Ribble Valley Borough Council  
Council Offices  
Church Walk  
Clitheroe  
Lancashire  
BB7 2RA

Re. Planning Application No. 3/2021/0077 – Smithy Cottage, Birks Brow

PROPOSED SITE SECTION

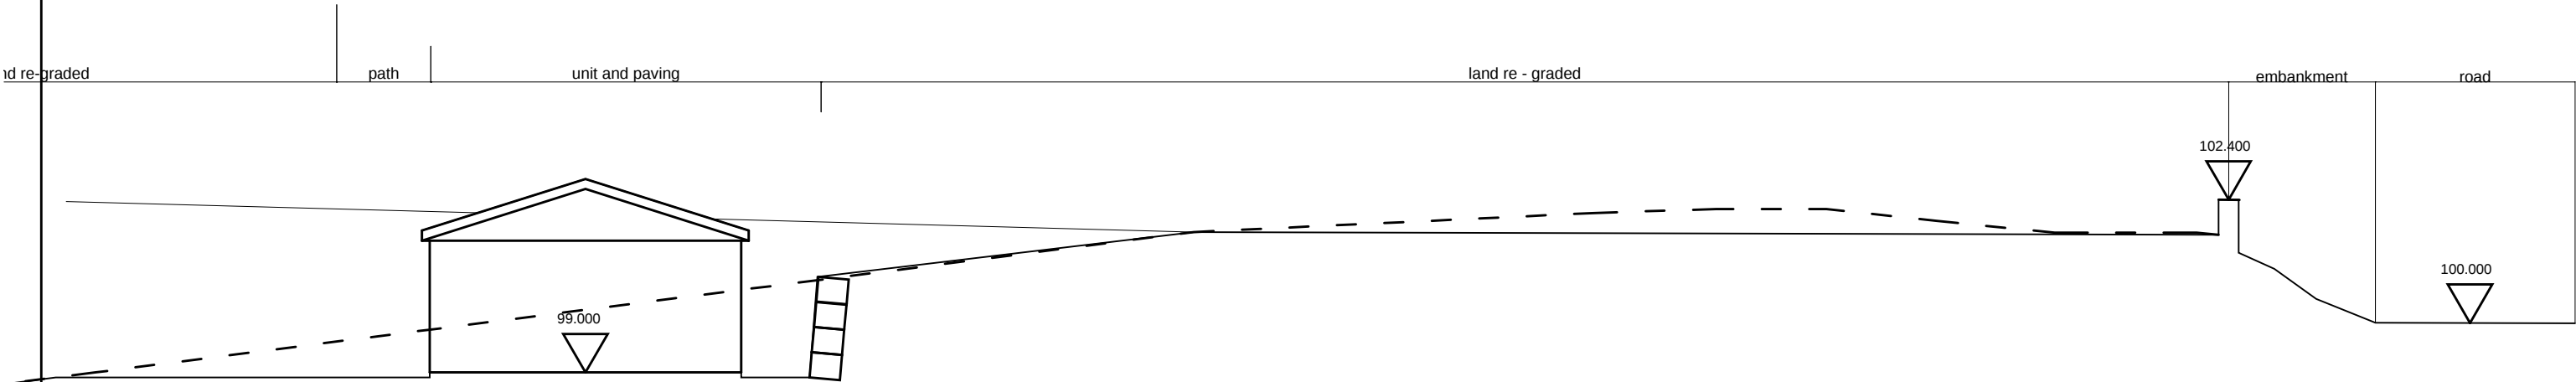
- Section shows relative levels in a single direction only. Our property [REDACTED] lies due North of the proposed development (assuming the 'North' arrow is correct as shown on the plan) and the land falls sharply from proposed location of works to our property. As such the development will have a significant adverse visual impact on our property and noise from those inhabiting a 3 bedroomed Lodge would carry as the area is currently extremely quiet.

- The physical size of the Lodge would be very imposing. The footprint appears to be larger than Smithy Cottage itself.  
The orientation of the Lodge is not shown. It is marked only as a rectangular block with no access arrangement indicated.

- Proposed Trees / Hedgerow appear to provide a degree of screening to minimise impact on the owner's Cottage and from Forty Acre Lane but offer no such protection to our property. The addition of screening along the length of the boundary between the development plot and the owner's main field (blue line on plan) would reduce visual and noise related impact on our property. As we own the adjoining field we could of course provide such screening ourselves but this would need to be in the form of rapid growing trees such as conifers to the full length of our field whereas trees of lower height, provided by the applicant on the boundary of his application, would achieve a better end result.

- Proposed location of Waste Bins is not shown.
- Proposed location of Septic Tank is not shown.
